From: Sam Dowley <sam@dowleycoarc.com>
Sent: 27 September 2022 15:48
To: Connor Smalls [REDACTED]
Cc: Mortimer, Darr [REDACTED]; Steven King [REDACTED]
Norfolk.gov.uk>
Subject: 22/01559/F The Maltings, Tower Road, Burnham Overy Staithe.

I have prepared a formal re-submission based on the conversations I've had with both Darren and Steven. Please see the attached.

Drawing: Existing east & west facades  
Scale: 1:150 @ A4

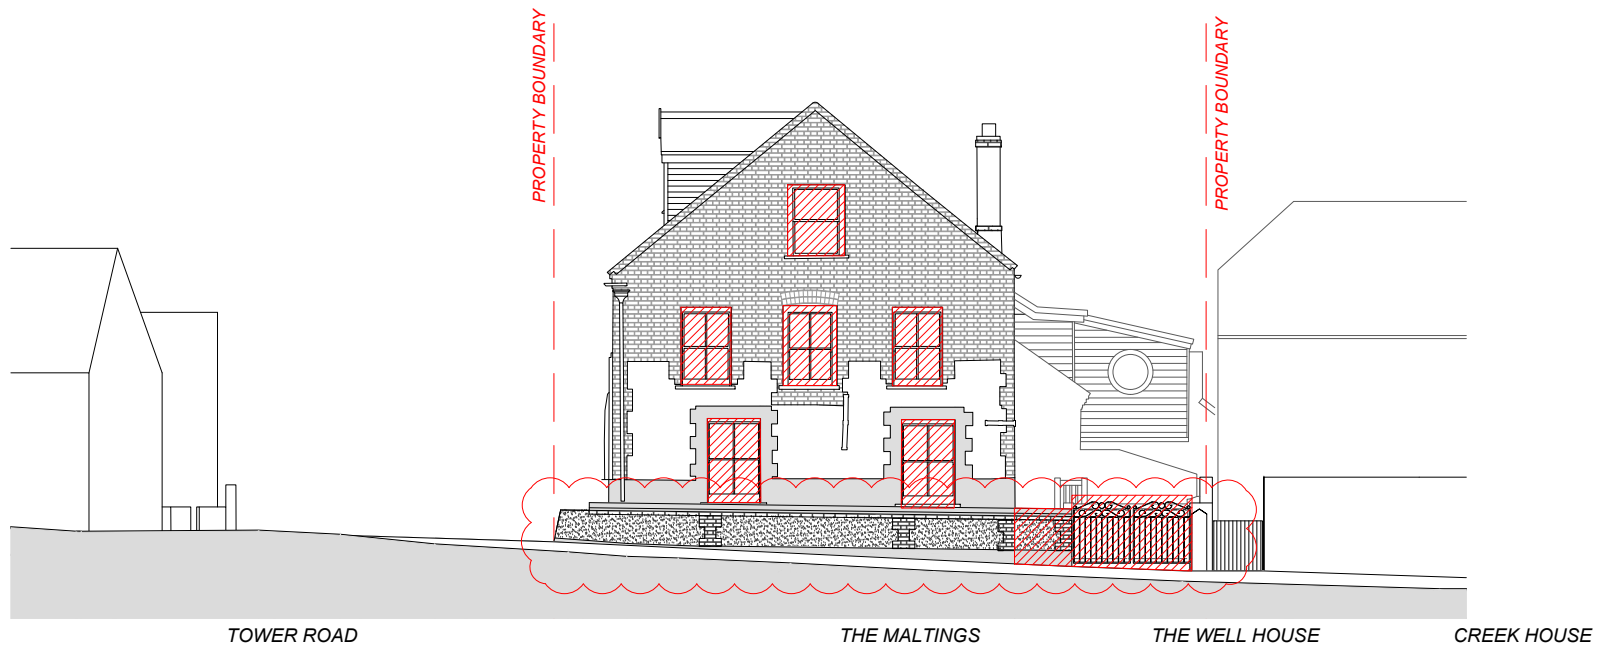
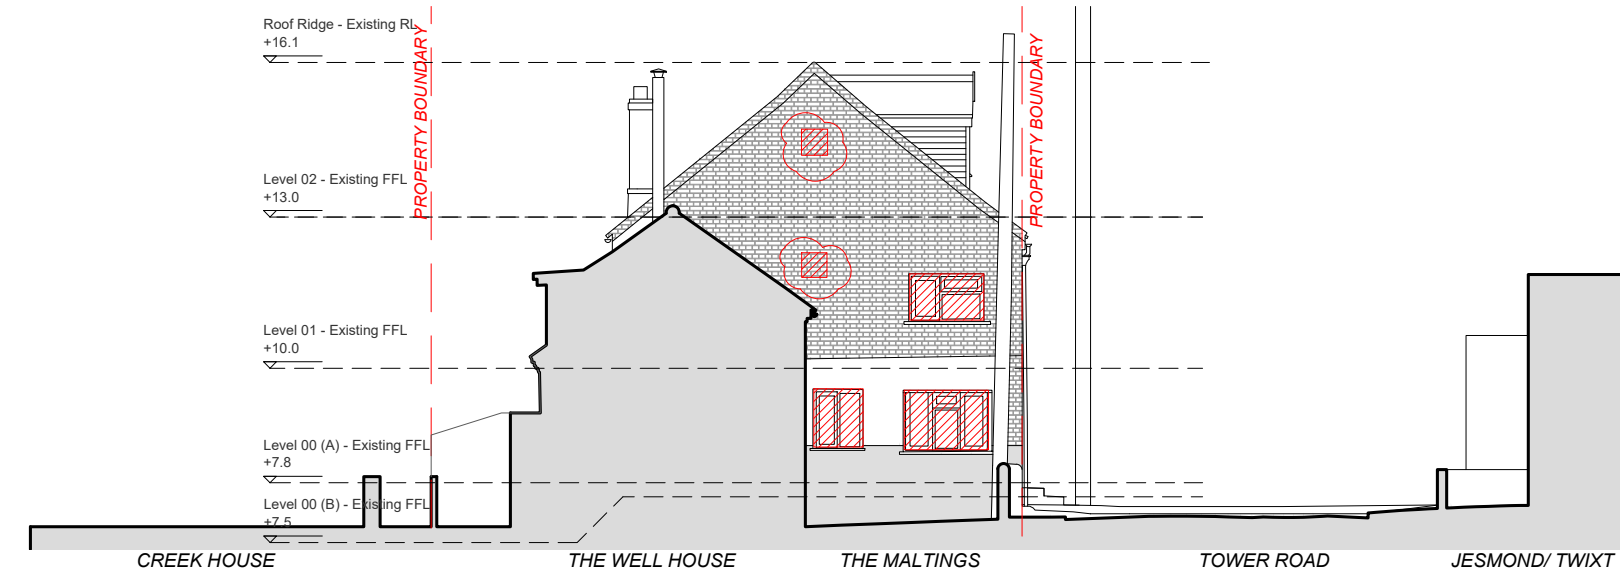
Steven: The high level windows on the North Facade have been re-sized and re-arranged. The two new windows on the West Facade have also been resized and aligned. There have also been some adjustments to the arrangement and quantity of conservation roof lights. As the parking will remain largely as is, the garden wall will also remain largely as is however with the opening increased to accommodate a larger vehicle.
